Comments for Planning Application DC/20/2254/HH

Application Number: DC/20/2254/HH

Address: 4 Reeds Buildings Bury St Edmunds IP33 1HU

Proposal: Householder application - a. front porch b. rear two-storey extension

FIRST FLOOR PLAN

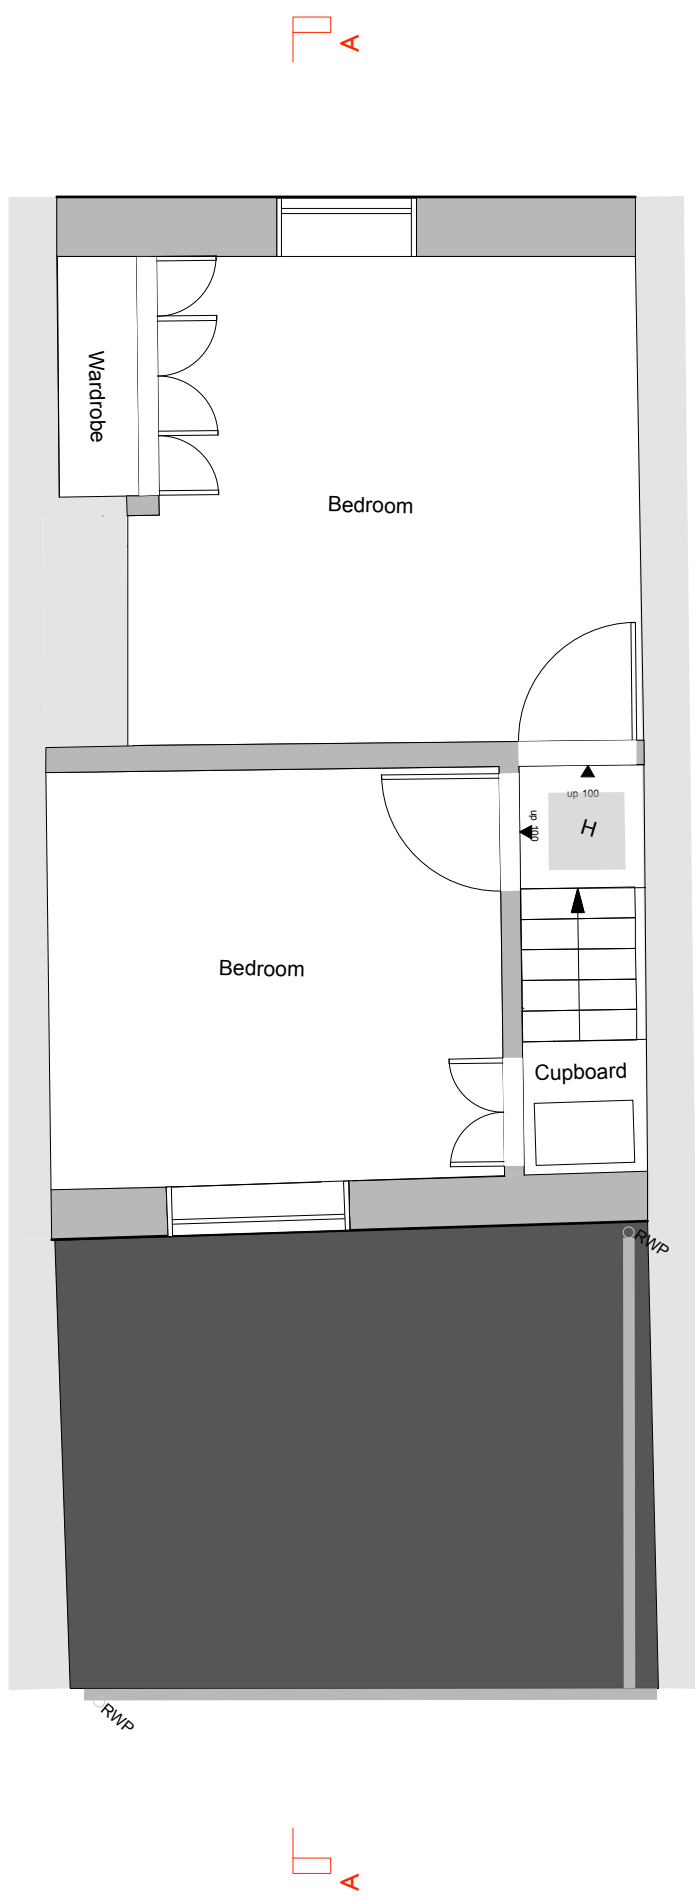
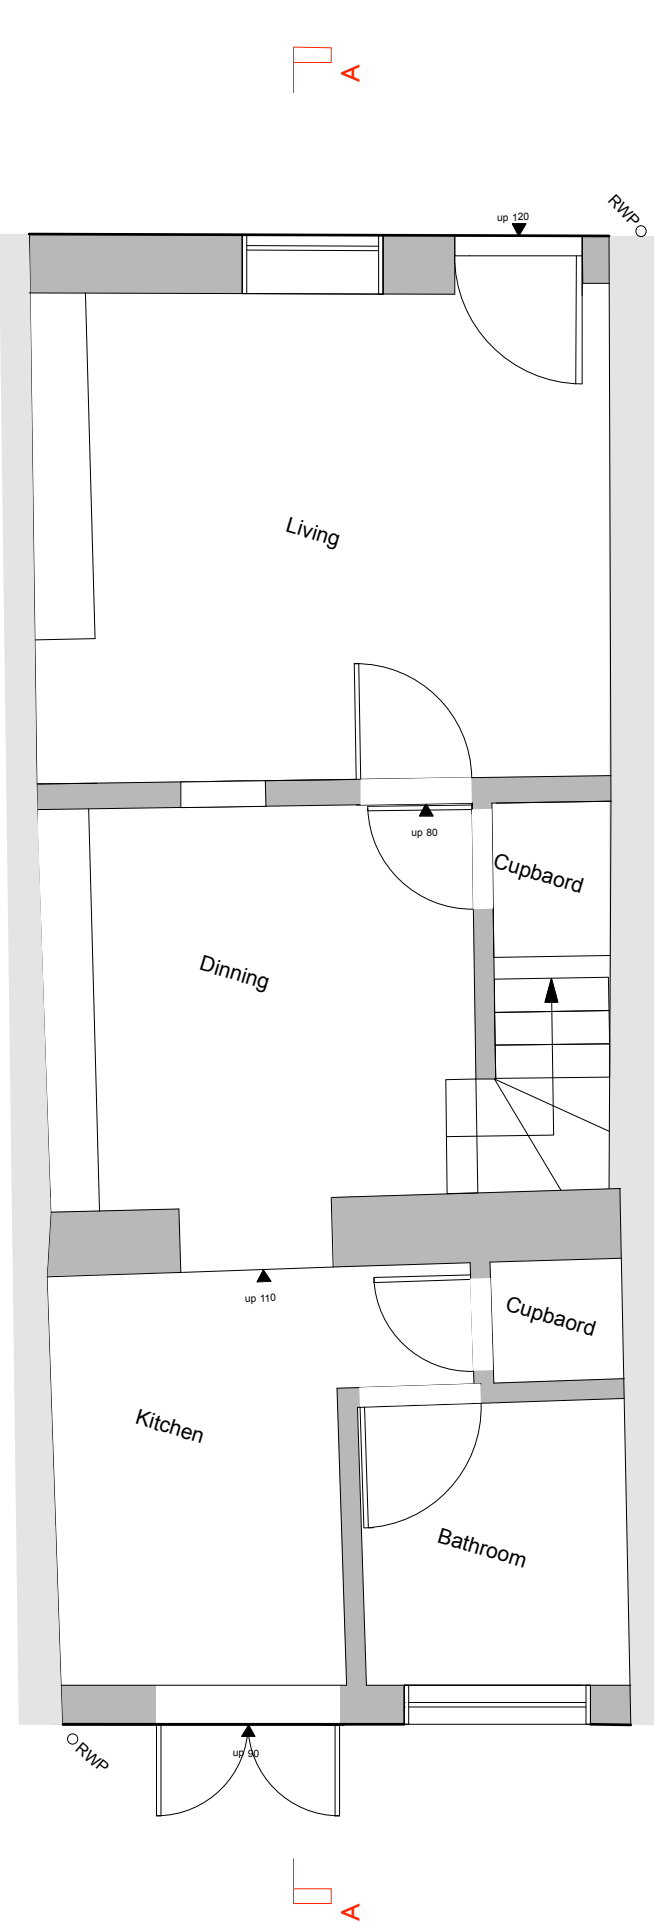
Suggested upper storey proposal would affect lighting levels (both ambient & direct sunlight) that would reach the bedroom facing the parking lot. Loss of light is also linked to health issues & depression. There would also be the issue that the proposed lower walls of any new bedroom will cast shadows that will promote moss growth & require additional maintenance to ensure that ingress does not damage the property

Direct sunlight currently falls into the affected bedroom in the evenings for many months of the summer. A more generous azimuth of 270° and elevation of 20° would see direct sunshine cast into the drive facing bedroom from the 1st week in May until Mid August

Any suggested upper level extension would reduce light reaching the neighbouring bedroom and is likely to affect the level of enjoyment of the house

There are also concerns that the length of the extension going beyond the existing house would break the 45° rule in the horizontal
